Re: Permit 2005-027

Project: Belady Garage; Project address: 7627 78th Ave NE, Mercer Island, 98040

This letter is a follow-up to questions regarding the Intake Comments CST dated 6/23/2020. Particular comments are addressed below. Changes as request in the comments are identified by Delta 1 on the drawing sheets.

A4.01

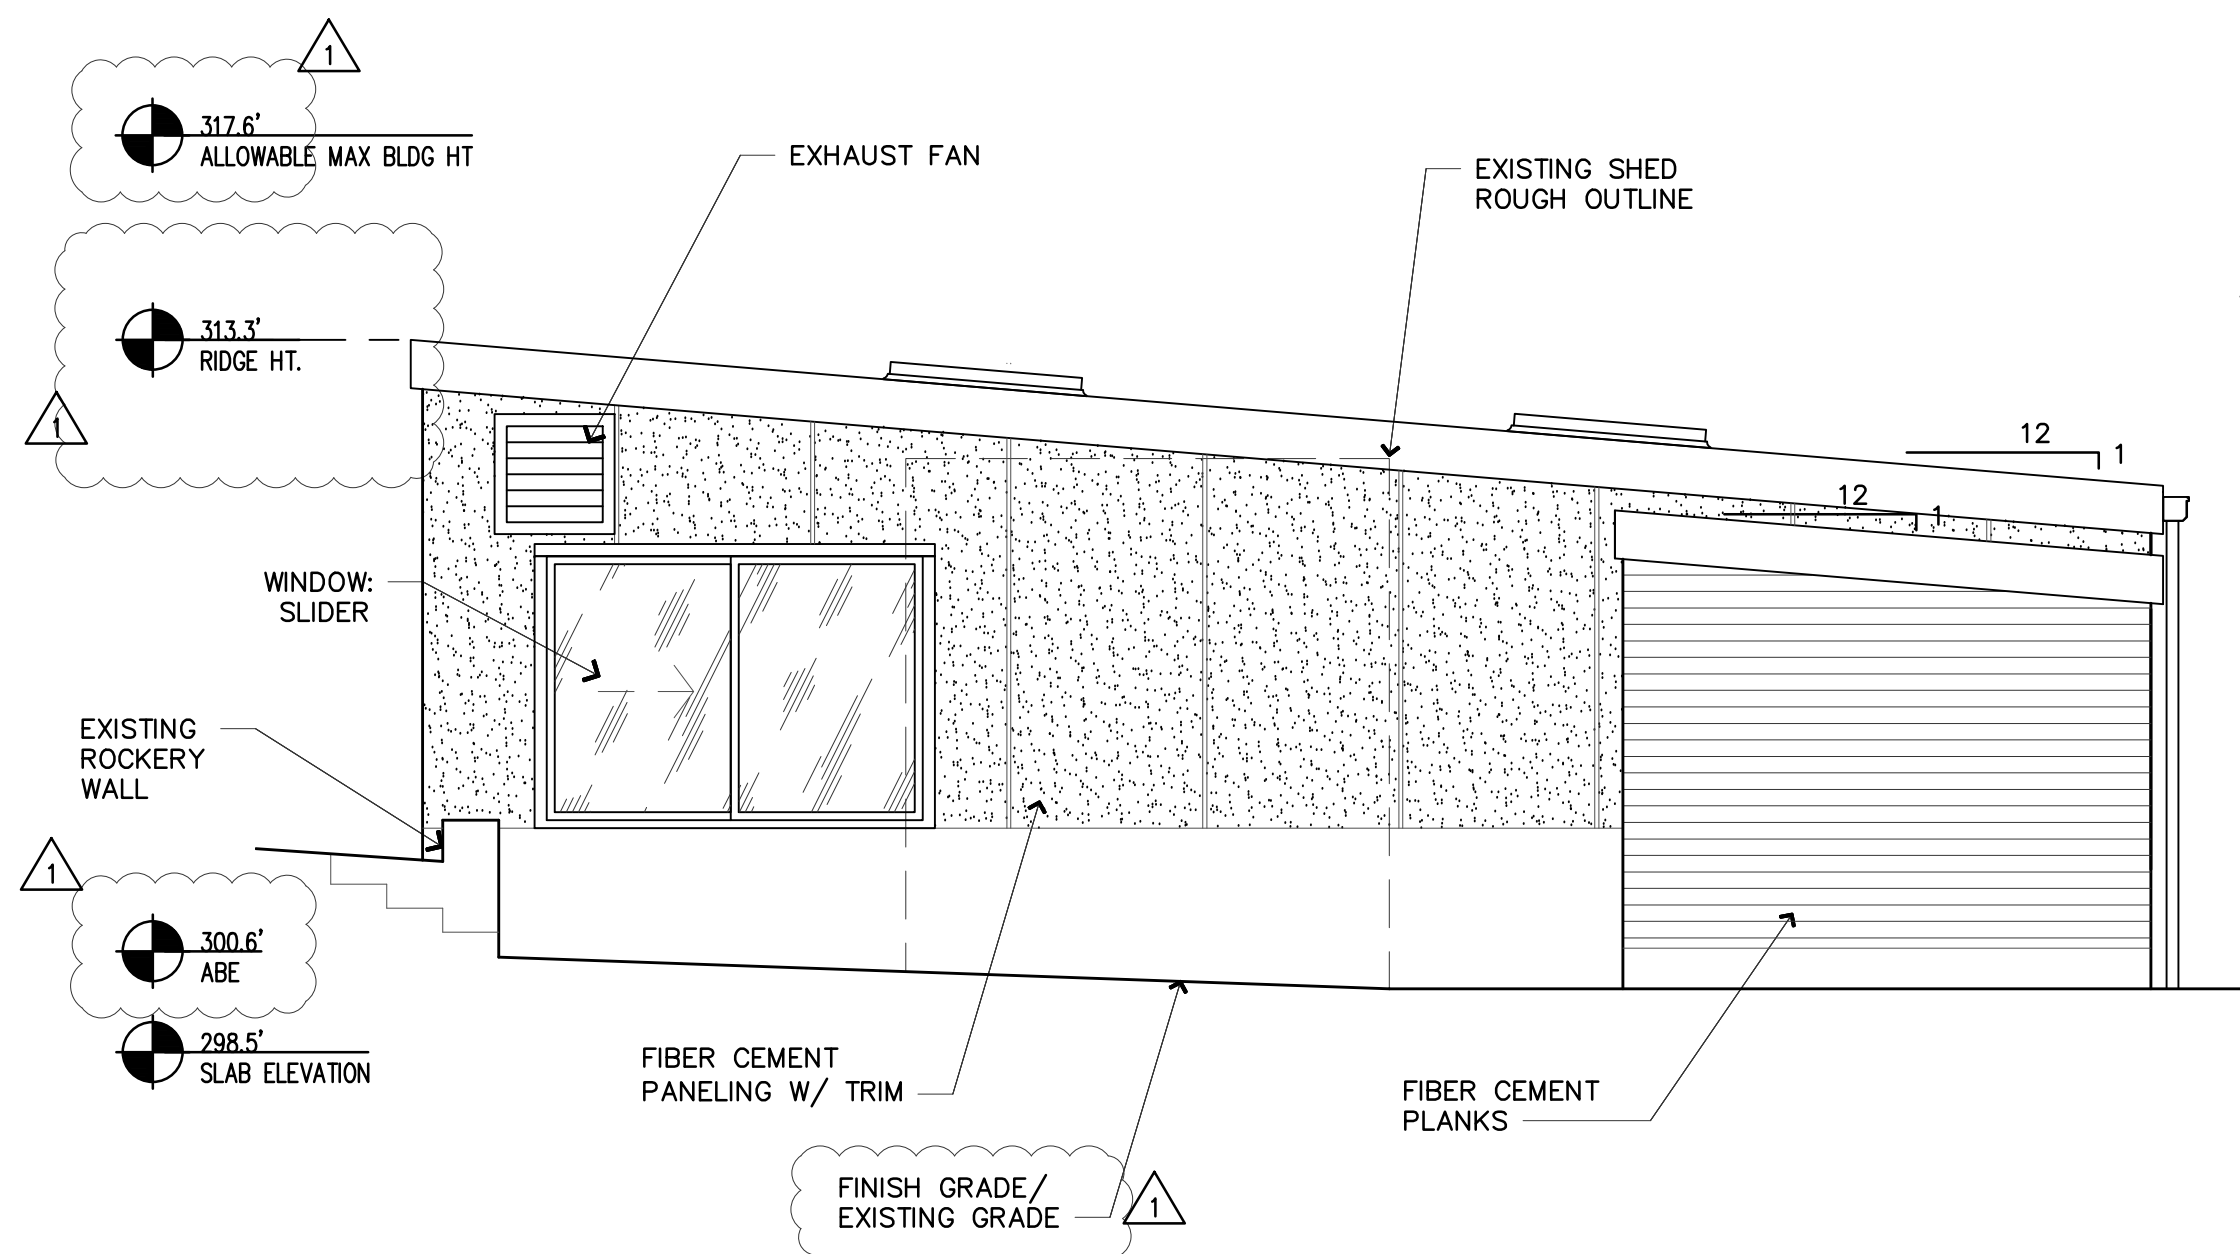
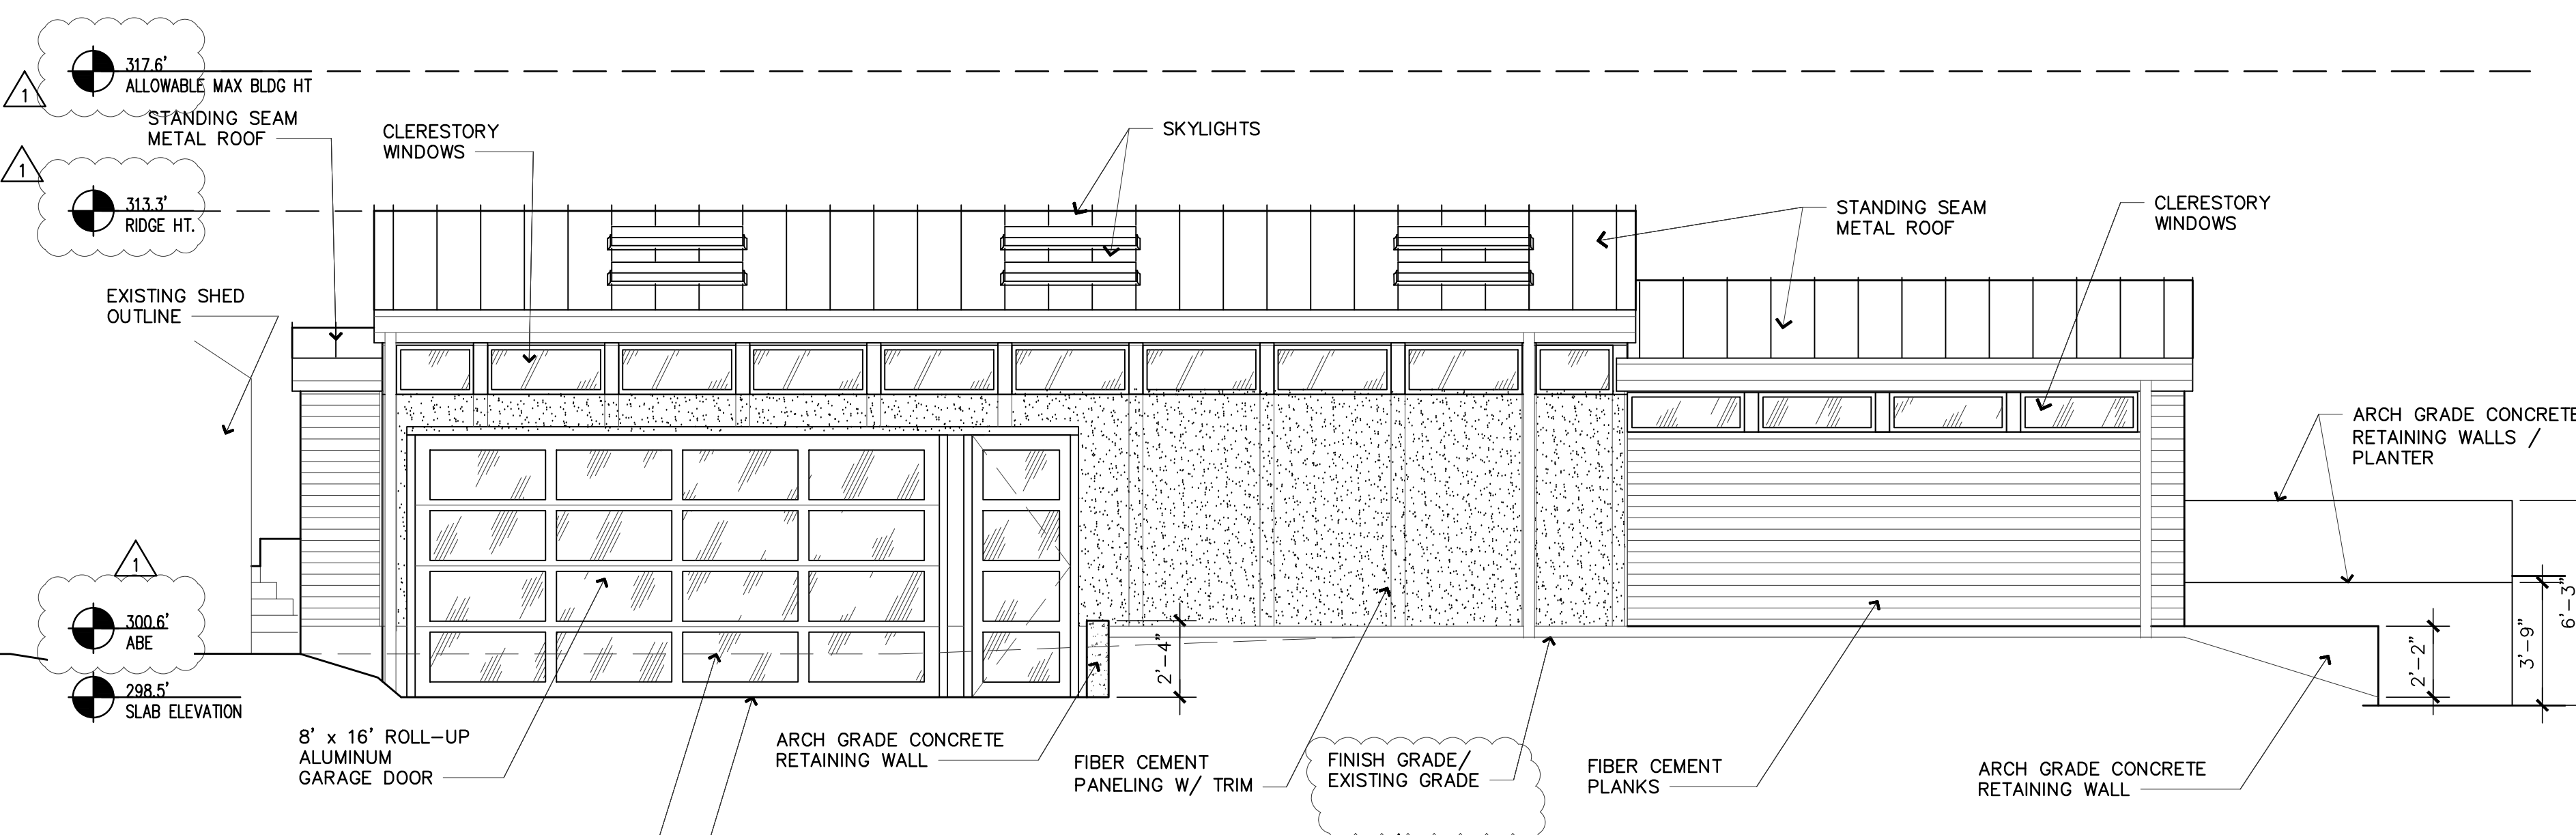
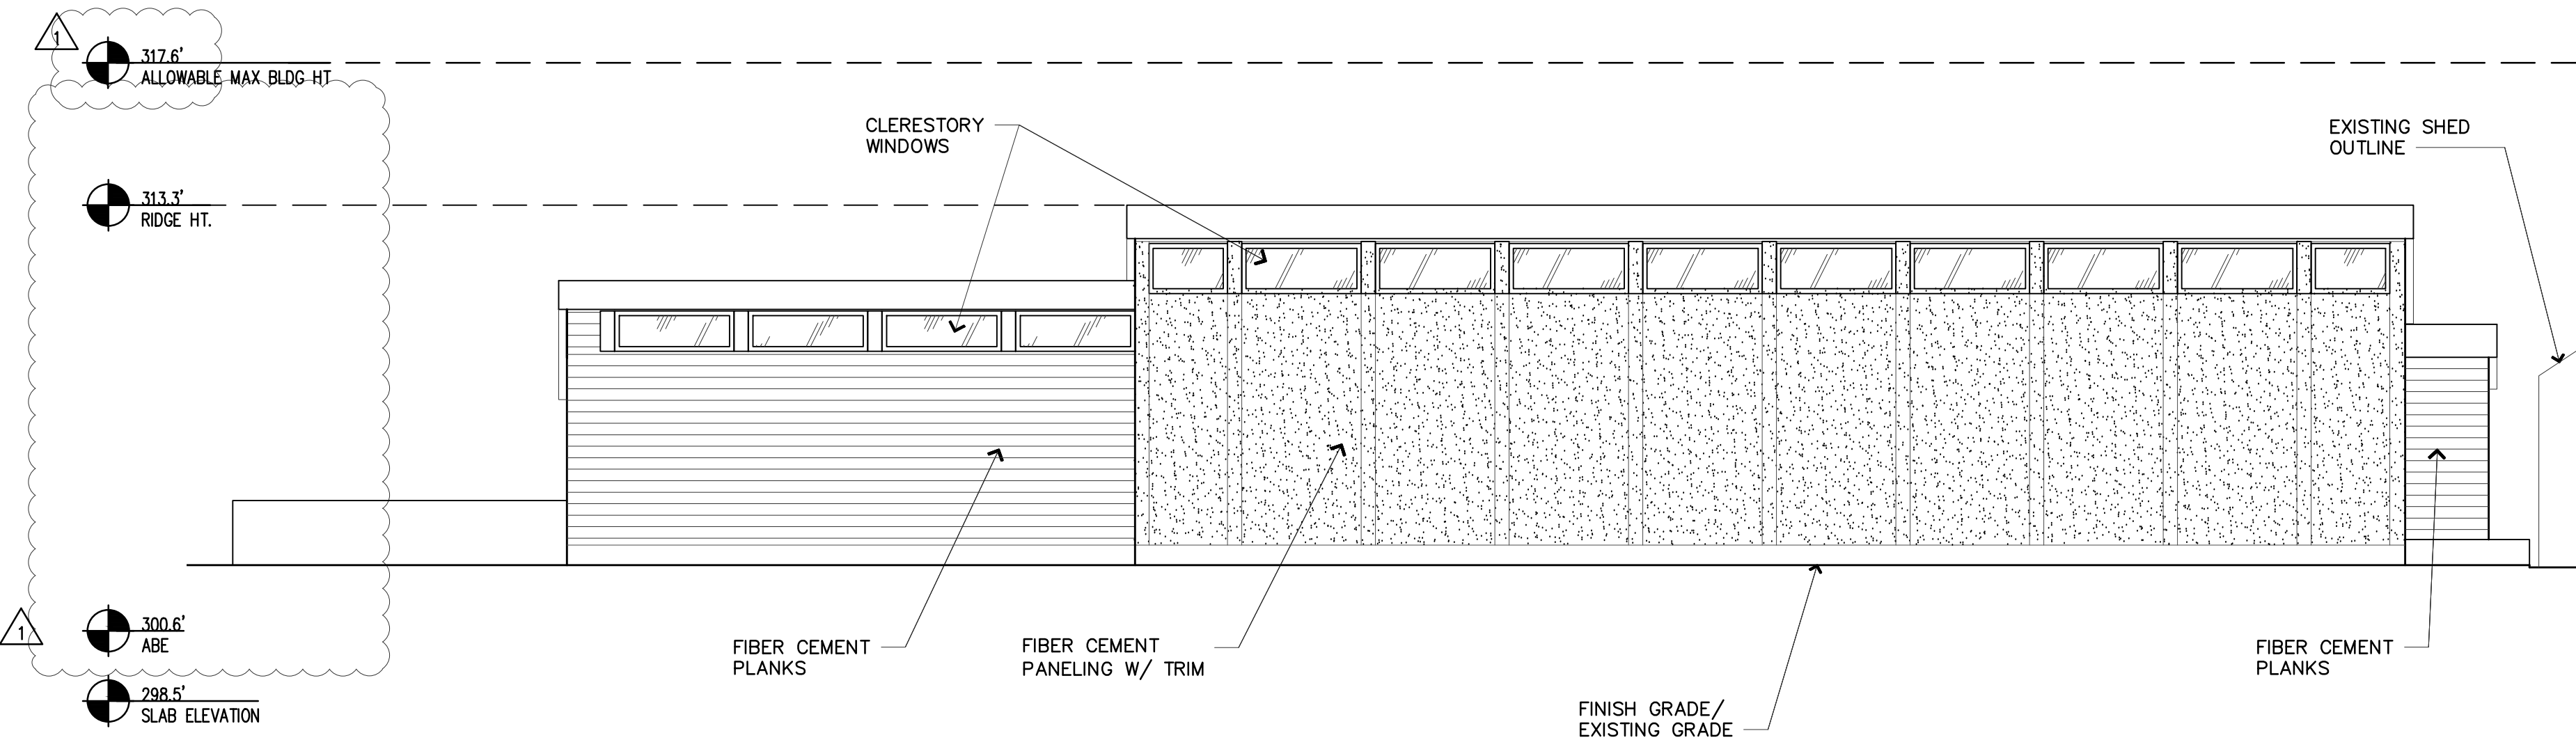
> Elevation Drawings. Refer to sheet A4.01. The corrected items are identified by Delta 1 symbol, including the following; Indicate buildings and proposed height; Indicate existing grade and finish grade; Indicate average building elevations (ABE) on all elevations drawings with ABE calculations table; Height of appurtenances above max height (none); Indicated allowable building height on all elevation drawings.

ABE table and dimensions, existing and finish grade, proposed building height and max building height are added to the elevation drawings. Refer to sheet A4.01.
